Your ref: N6/2010/2055/MA

**BROADWATER ROAD WEST
ENVIRONMENTAL IMPACT ASSESSMENT
VISUAL AMENITY AND ARCHITECTURE**

BROADWATER ROAD WEST, WELWYN GARDEN CITY
 DETAILED PROPOSALS: LEISURE CENTRE (BUILDING A)
 PROPOSED SECTIONS AND ELEVATIONS
 568_07_220

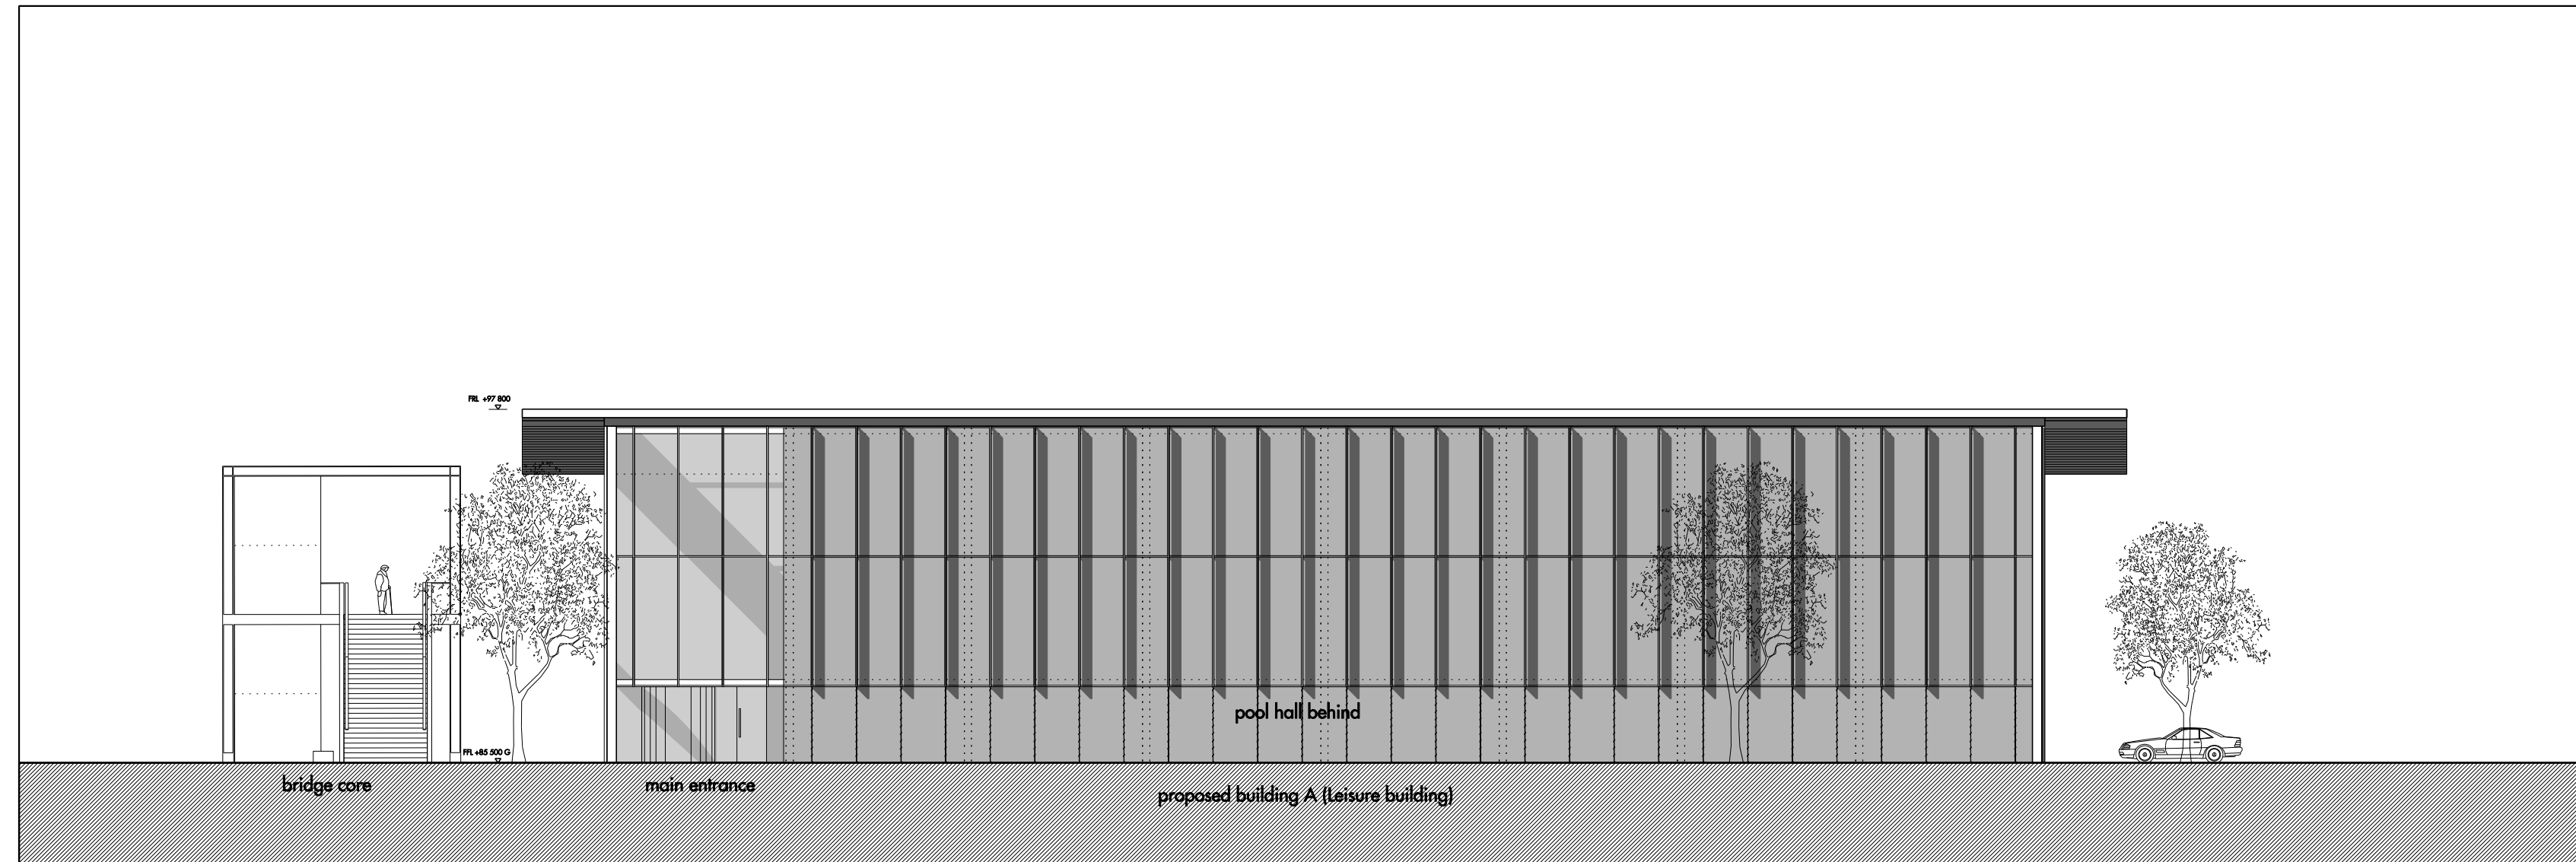
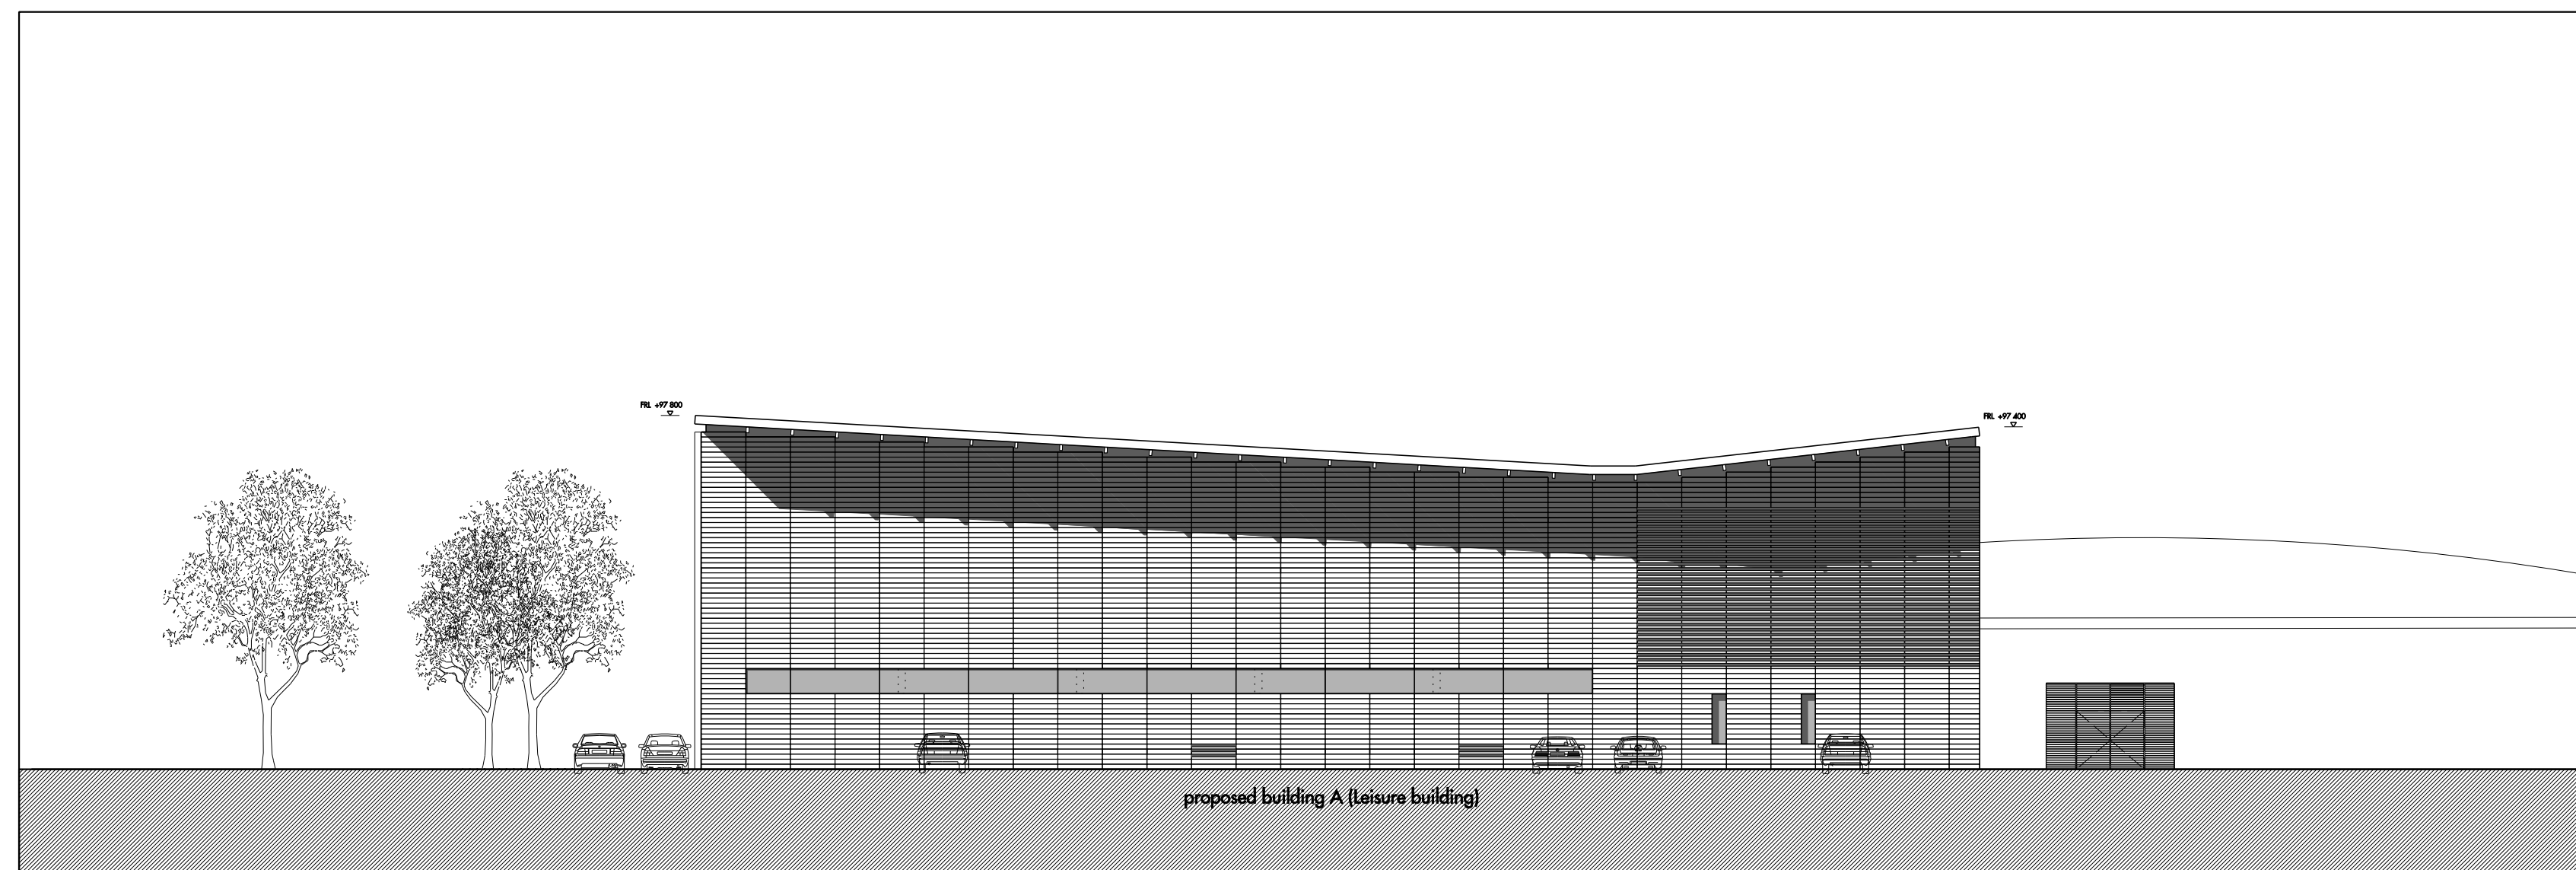
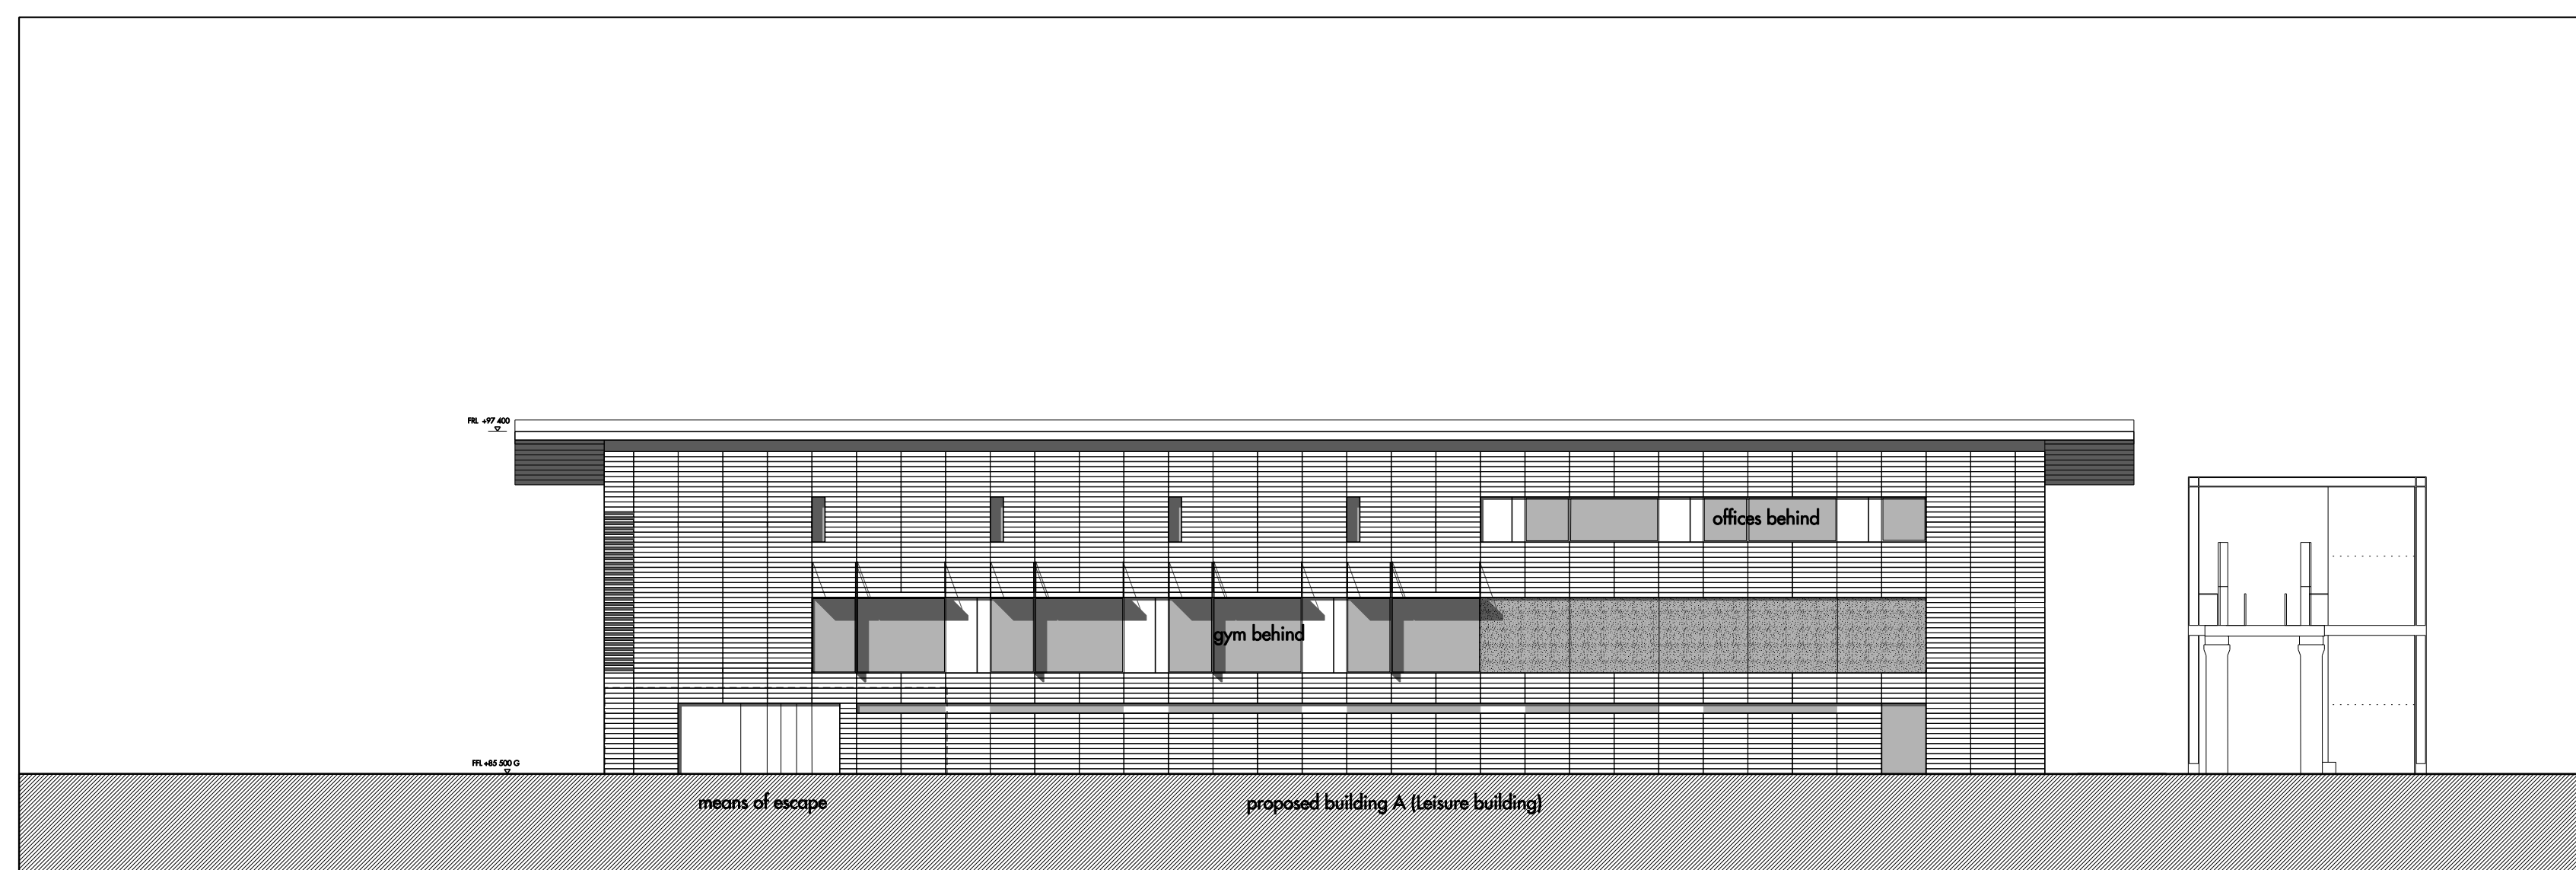
In spite of its title, this document makes little reference to architectural style and appearance. Such elevations as are shown, of commercial, community and residential buildings, are banal in the extreme. I assume they are just diagrammatic. Far more detail is required, and the Council would need to approve the final designs. Some recent WGC housing is disappointingly mundane. With a shortage of internal architectural staff, I suggest that the Council needs an independent (RIBA?) design review panel to advise on design quality and ensure the high standard promised.
